**PROPOSED FLYERS CREEK WIND FARM
BLAYNEY SHIRE COUNCIL AREA
MP_08 0252**

Re: Infigen's application for Modification 3

SUBMISSION

Re: Flyers Creek Wind Farm MP 08_0252 – Modification 3

Flyers Creek Wind Farm Layouts

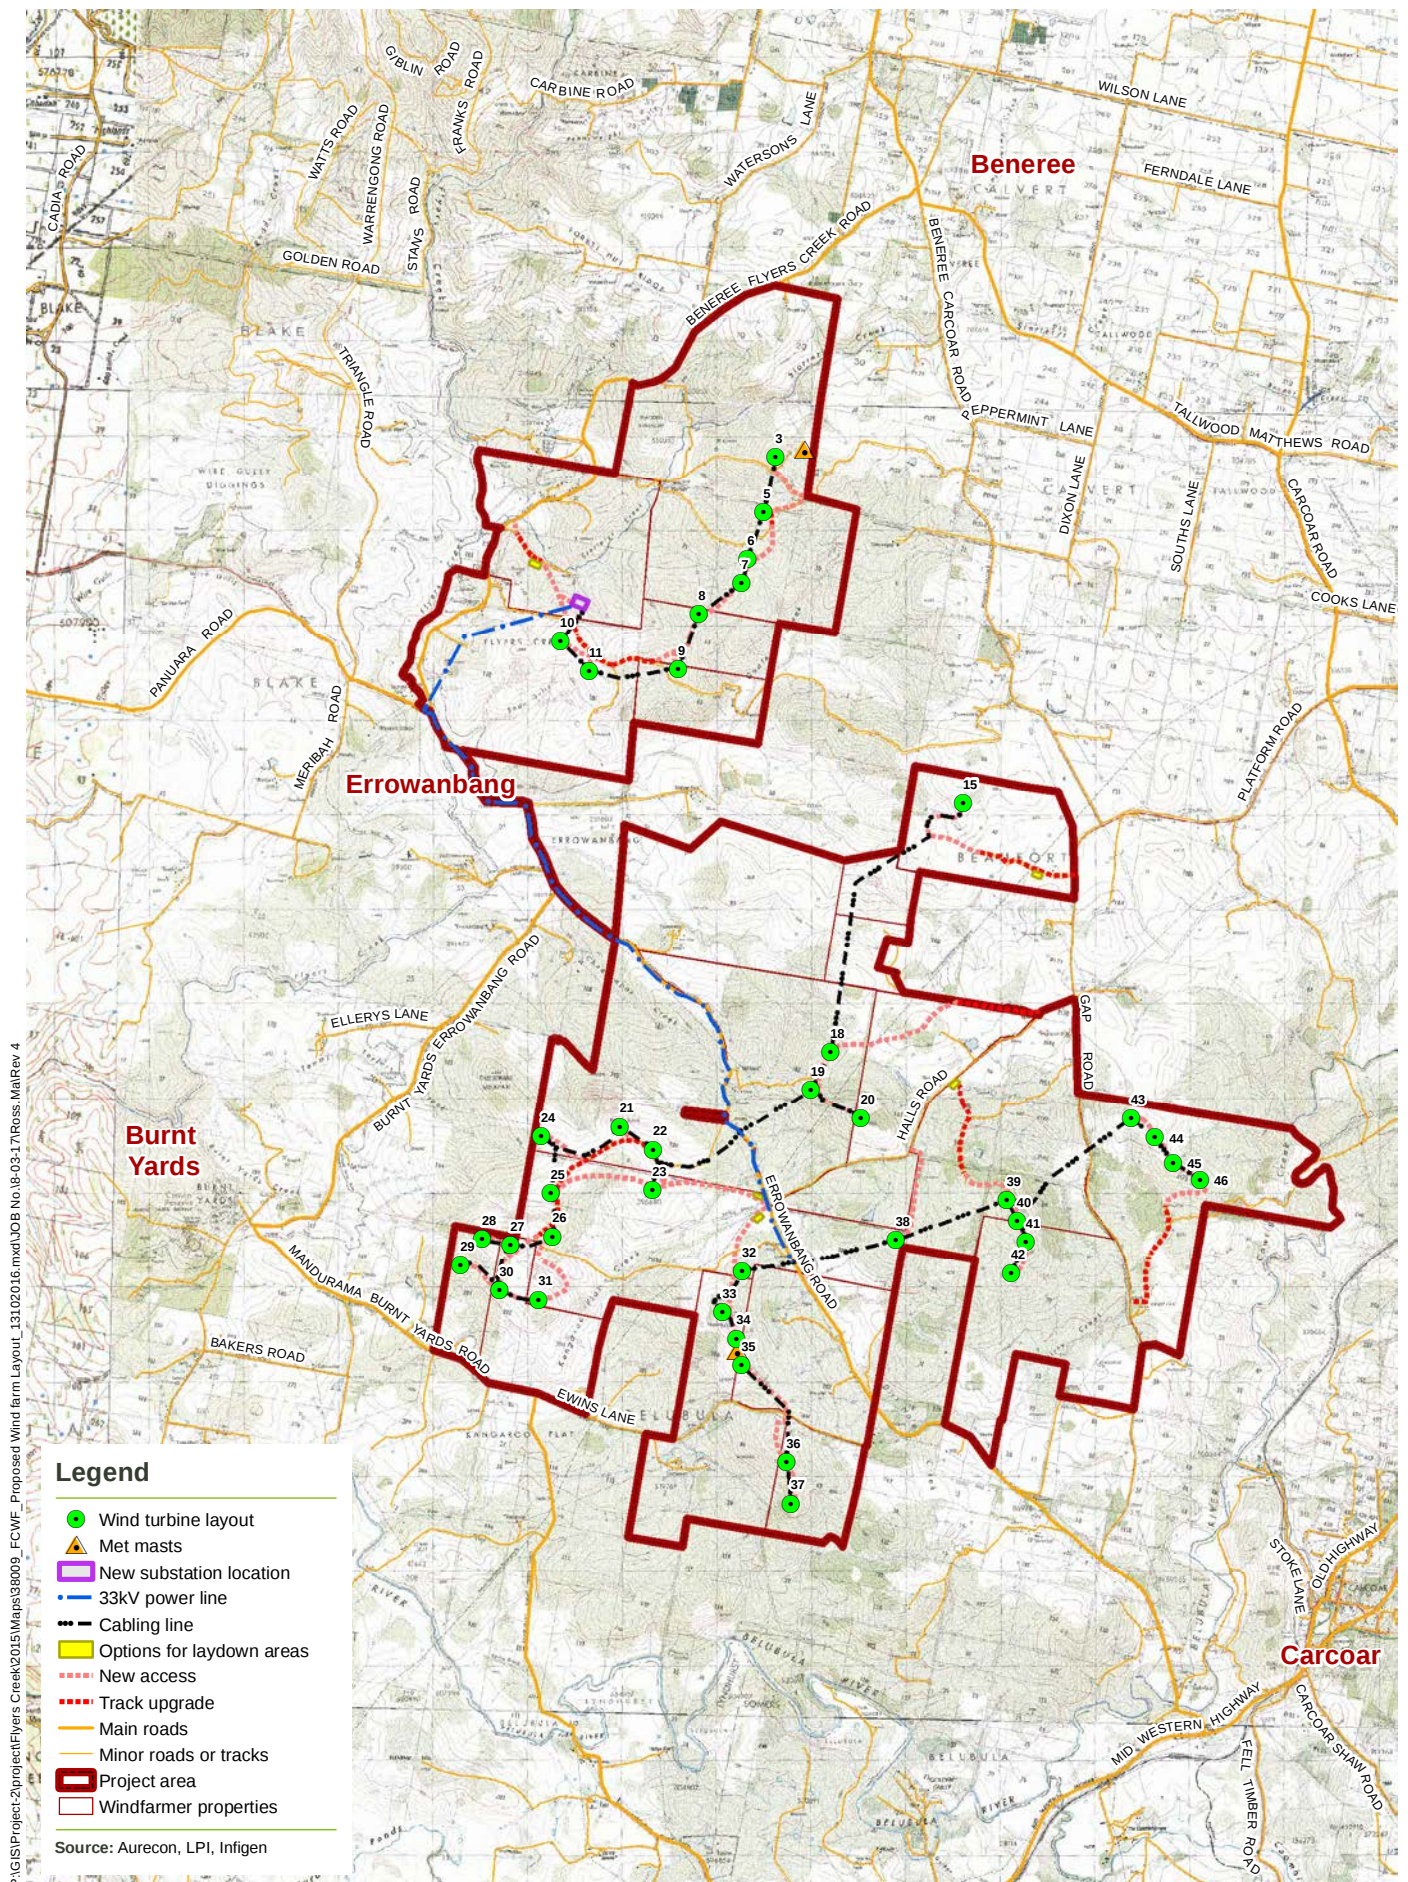
Previous IWT hosts at R014, R024 and R056 are no longer participating in the wind farm project. In so doing IWTs 4, 13, 14, 16 are to be removed from the project. This forms part of Modification 3. These three properties become non-hosts and should be allowed the same considerations as other non-hosts.

The closest IWT to R014 will now be #9 at 1.3 kms.

The closest IWT to R024 will now be #3 at 1.8 kms.

The closest IWT to R056 will now be #15 at 0.9 kms.

In this very particular instance the residents of R014, R024 and R056 should have those IWTs that are less than 2 km from their property removed, i.e. IWTs 3, 9 and 15.

While we argue the specific impact that will remain for the now non-hosts at R014, R024 and R056 with the retention of IWTs 3,9 and 15, in fact there will be unacceptable impacts for the whole Flyers Creek Wind Farm area.
